Application number: 2021/90800	
What is the application for?:	Redevelopment and change of use of former mill site to form 19 residential units
Address of the site or building:	Hinchliffe Mill, Water Street, Holmbridge, Holmfirth, HD9 2NX
Postcode:

Type of comment: An objection	
Do you wish your comments to be published on the website anonymously?	Yes
<p>Although on principle I support the development of the mill building and the land behind the mill, as I would much prefer it to be utilised to compliment the area and to maintain the natural landscape and wildlife of the mill pond rather than allow the whole centre point of the village to be left to go to further ruin, I cannot support the amended plans as they do not address key issues.</p> <p>Over intensification of the site is still a major issue as although the number of houses has been reduced from 24 to 19, 19 being the indicative maximum capacity allocated for the development of the site HS190 in the Kirklees Local Plan, the local plan does not identify the size of dwellings and with the majority of the proposed dwellings being large 3 and 4 bedroom properties, the volume of cars will be far more than a development of 19 2 b

HOUSE TYPE : UNIT 1

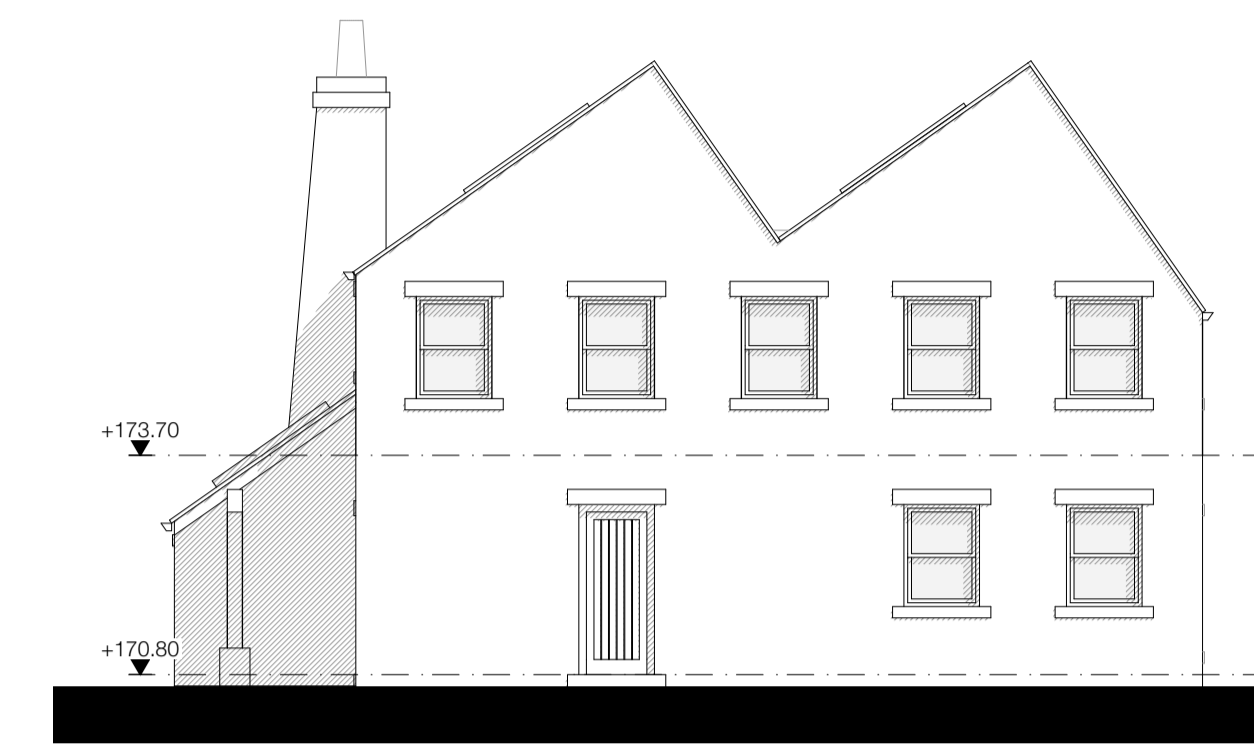
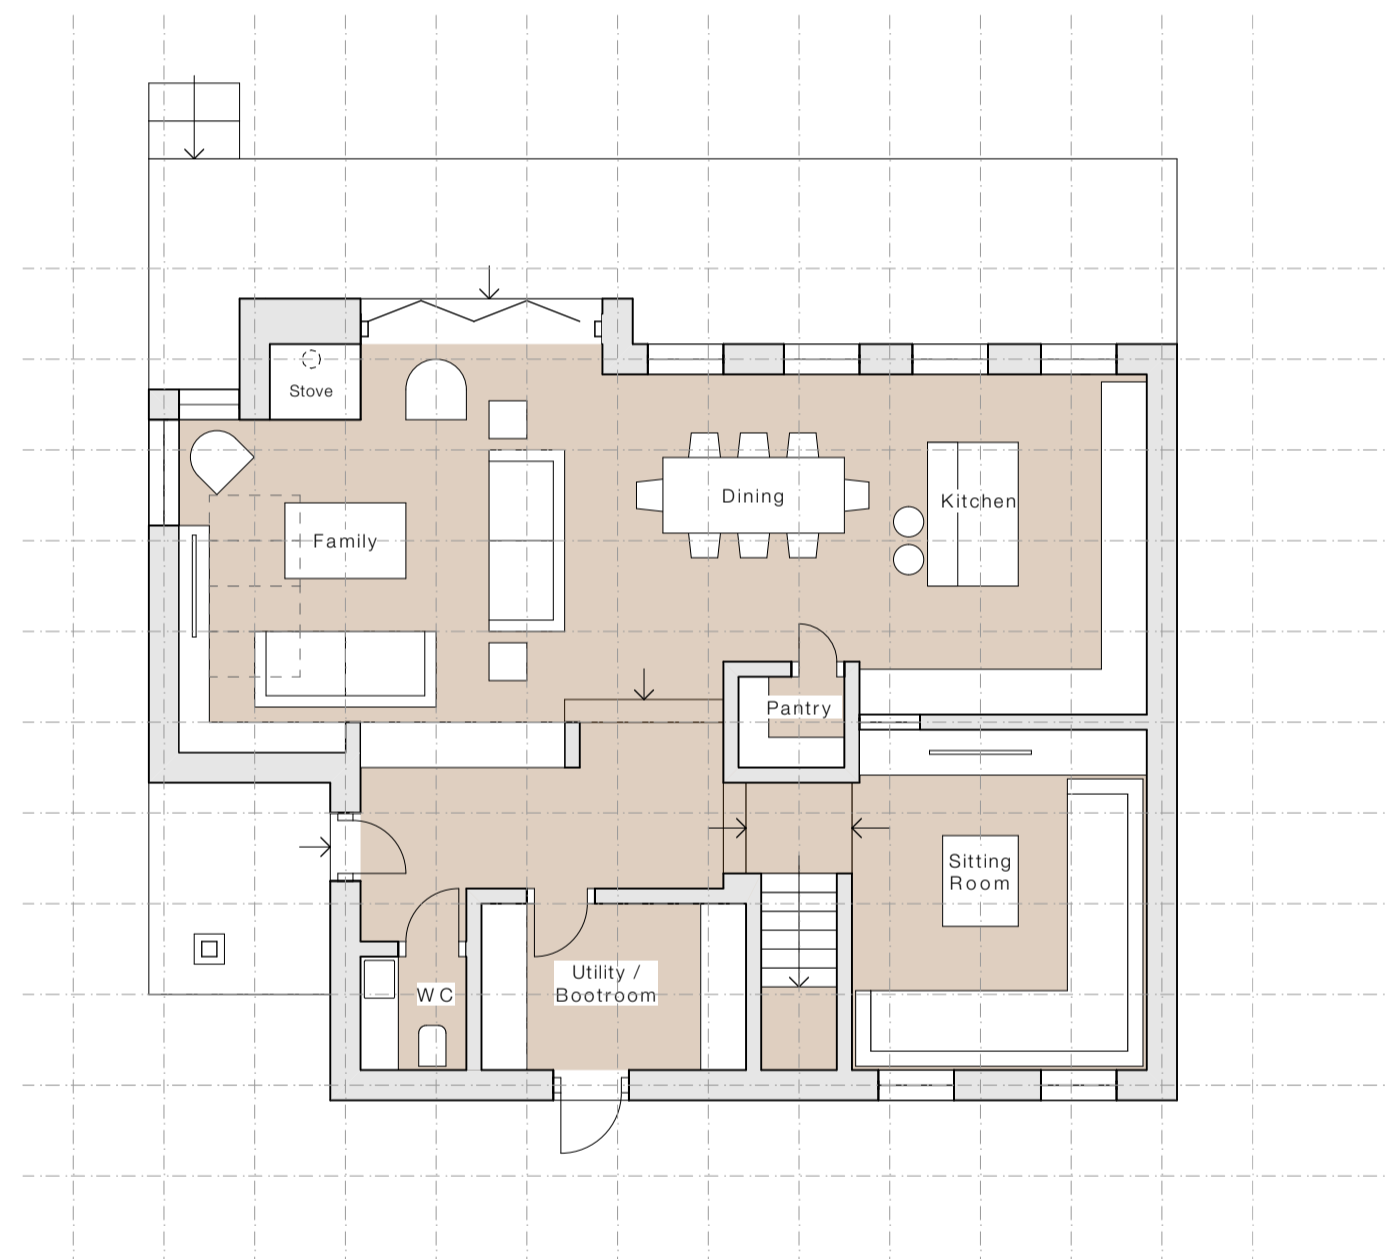
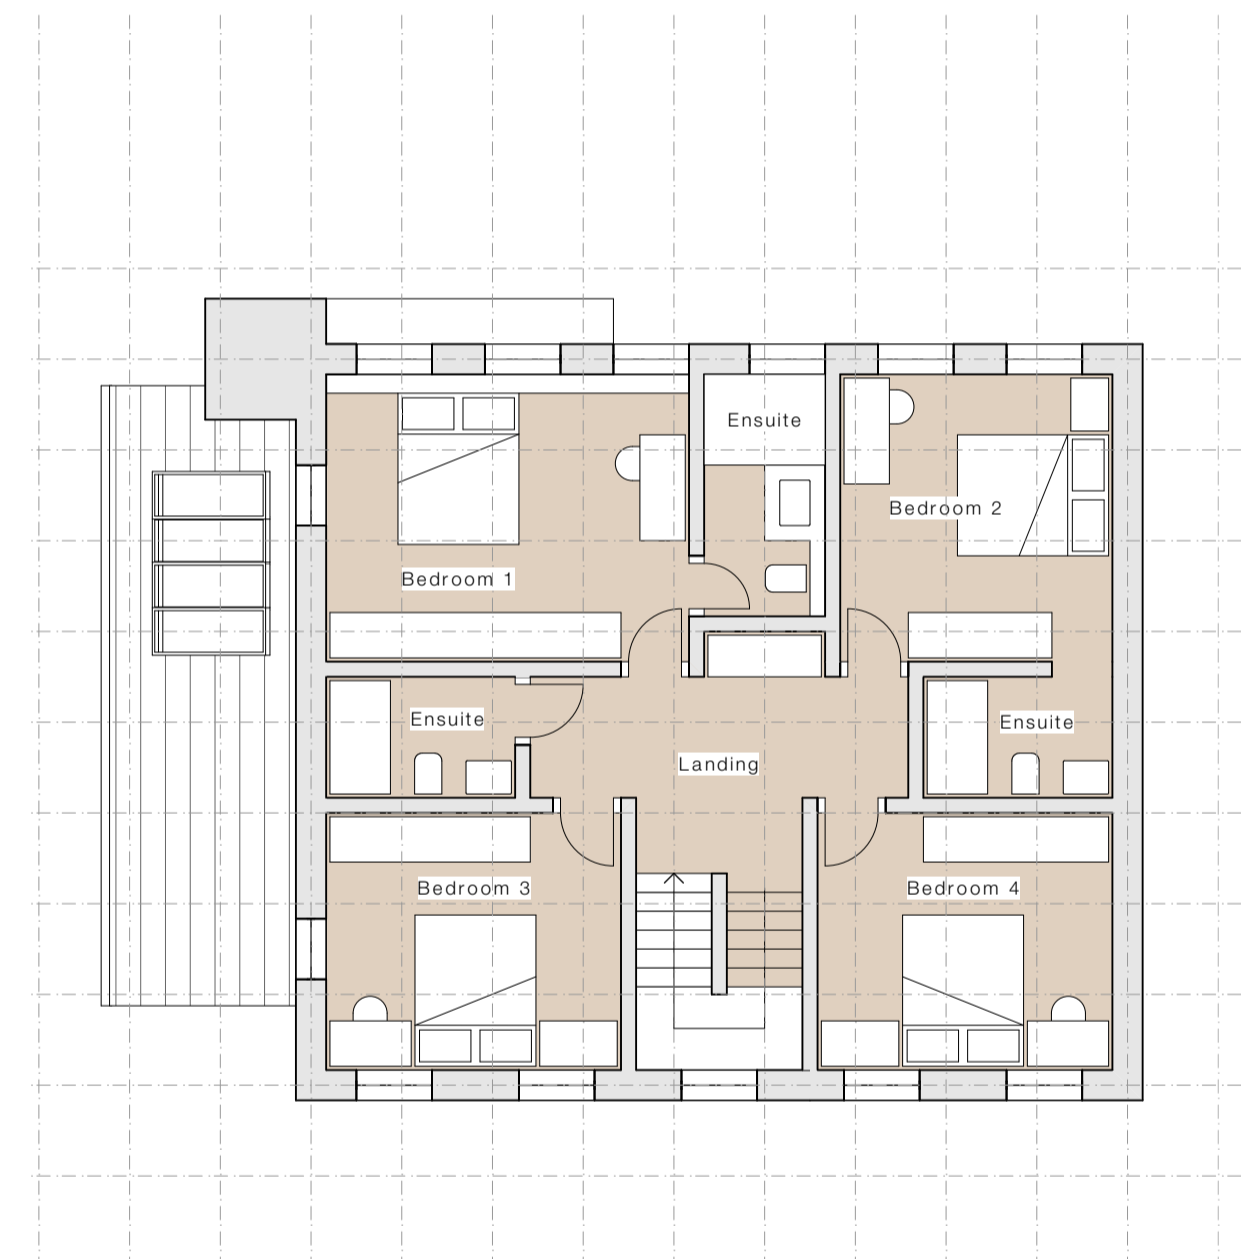
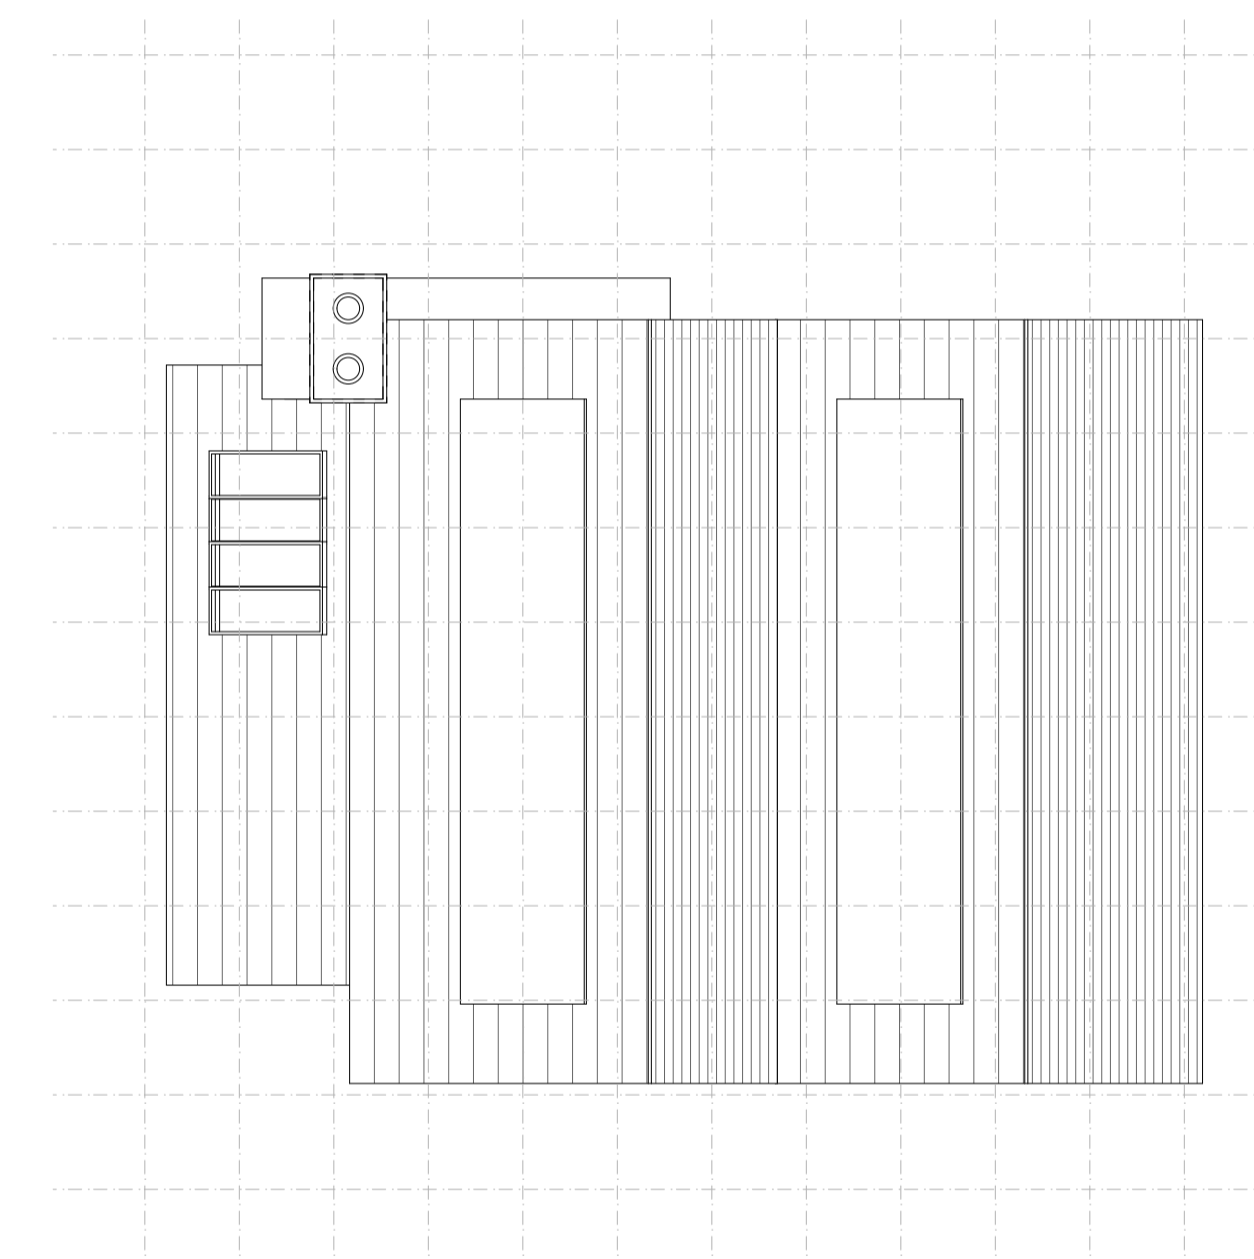
The scale and massing of plot 1 & 2 directly adjacent to the mill building, overlooking the dam are unduly dominant and out of scale with the heritage Class 3 asset mill building which would lose its local prominence, adversely affecting its village-scape merit and immediate setting. The 5 dwellings on the hillside above the mill complex are in a location that will dominate the village. They will in no way blend in or be hidden in the valley bottom as the majority of other dwellings in development will be. Historic England submitted concerns that previous plans presented a 'domestic' feel, at odds with the industrial character of the site which would not preserve or enhance the special interest of surrounding designated and non-designated assets and would be harmful to the character and appearance of the conservation area, and consequently cannot be supported. Complete removal of plot 1, or further reduction in scale and massing of plot 1 & 2 is required. Further design consideration is needed in keeping with the context of the industrial setting and surrounding properties in this conservation area.
